November 16, 2006

Re: Status of Improvement Permit Application #06-5-16072

On November 14, 2006, an Environmental Health Specialist from the Harnett County Health Department attempted to evaluate your property for the purpose of issuing an Improvement Permit. This individual was unable to evaluate your property for one or more of the following reasons.

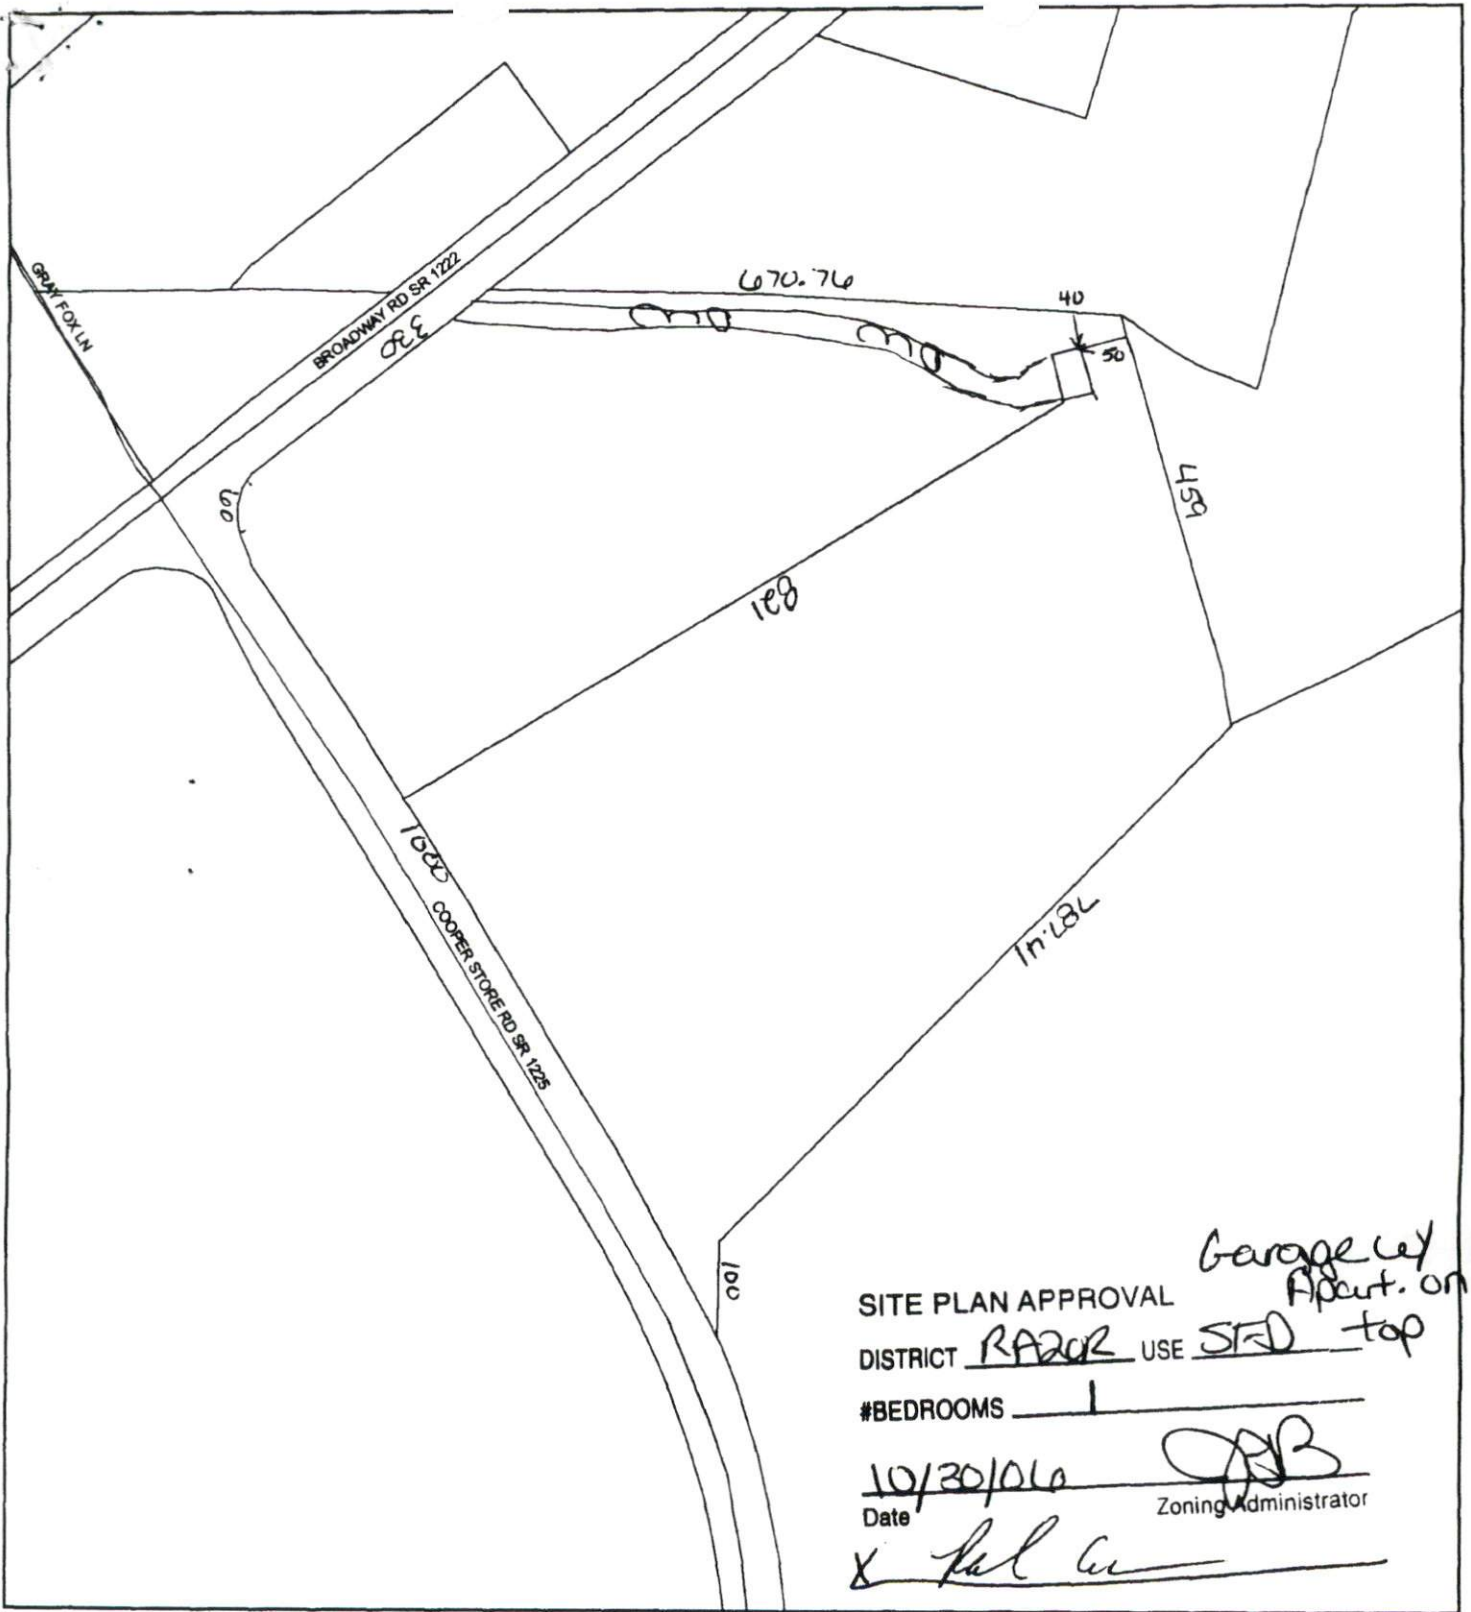
- 1. Property lines/corners not marked or labeled
- 2. House corners not marked or labeled
- 3. Directions not clear to property
- 4. Property needs brush or vegetation removed
- 5. Backhoe pits required – **Due to rocky soil conditions, backhoe pits will be needed. Have backhoe operator call to schedule time with me.**
- 6. Other – **What you have staked on ground does not match plot plan. Please correct plot plan to reflect what is staked on lot.**
